CITY OF ALBUQUERQUE

May 17, 2022

Re: Panda Express
98th St. NW
Traffic Circulation Layout
Architect's Stamp 05-09-22 (K09-D038)

TC 1.0

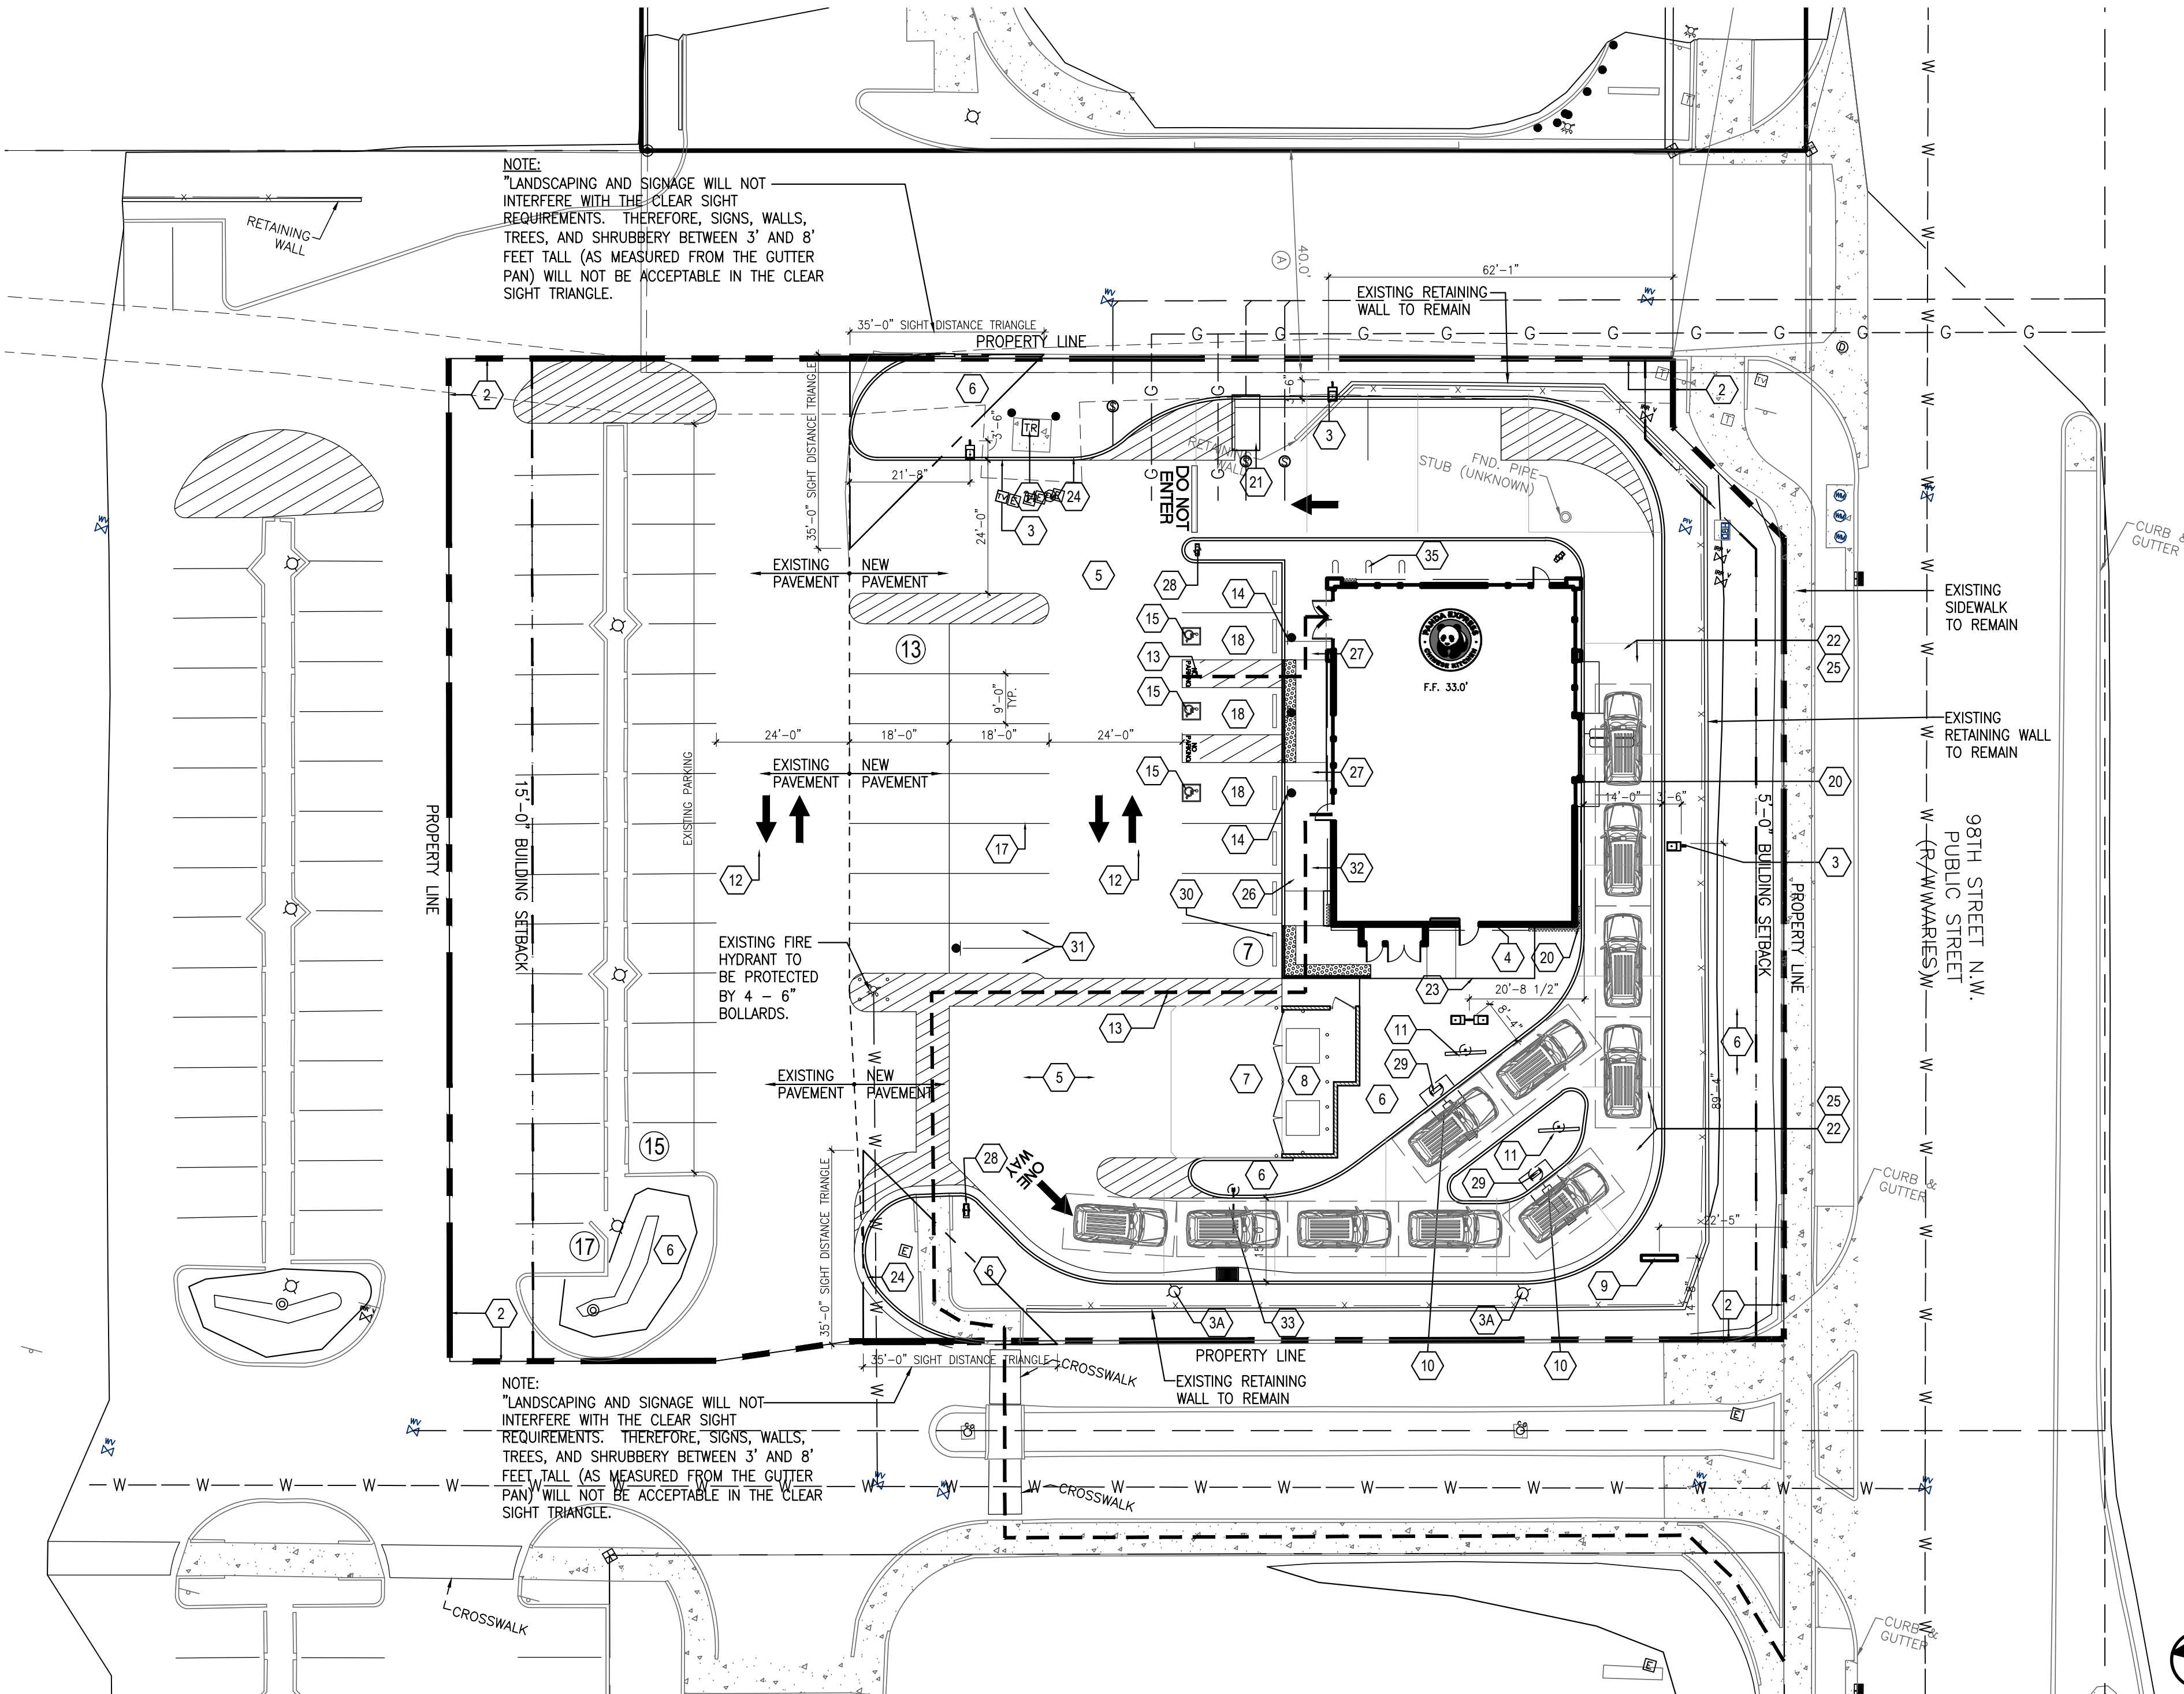
1. Identify the right of way width, medians, curb cuts, and street widths on 98th St. NW.
2. Provide the width for the streets at north side and south side of the site.

3. Provide the number of Bicycle parking spaces required by the IDO.
4. What will separate your site from the street on the north side of your site? Please address this concern.

5. Keynote 27: provide ADA ramp details and reference COA std dwg.
6. Define ADA pedestrian pathway by labeling of ramp, flush pavement and dimensioning of pathway.

7. ADA curb ramps must be updated to current standards and have truncated domes installed.
8. Provide dimensions for the existing parking spaces.
9. The pavement marking "MC" should be shown in the opposite direction for motorcycles entering the parking space.

10. Provide details for "NO PARKING" pavement marking. And provide details for all proposed pavements marking.
11. All one-way drives shall have "One Way" and "Do Not Enter" signage and pavement markings. Please show detail and location of posted signs and striping.

12. The minimum drive through lane width is 12 feet with a 25 foot minimum radius (inside edge) for all turns. (A 15 foot radius can be used with an increase in lane width to 14 feet). Please dimension all lane widths and radii.

13. Please provide a sight distance exhibit
14. Show the clear sight triangle and add the following note to the plan: "Landscaping and signage will not interfere with clear sight requirements. Therefore, signs, walls, trees, and shrubbery between 3 and 8 feet tall (as measured from the gutter pan) will not be acceptable in the clear sight triangle.
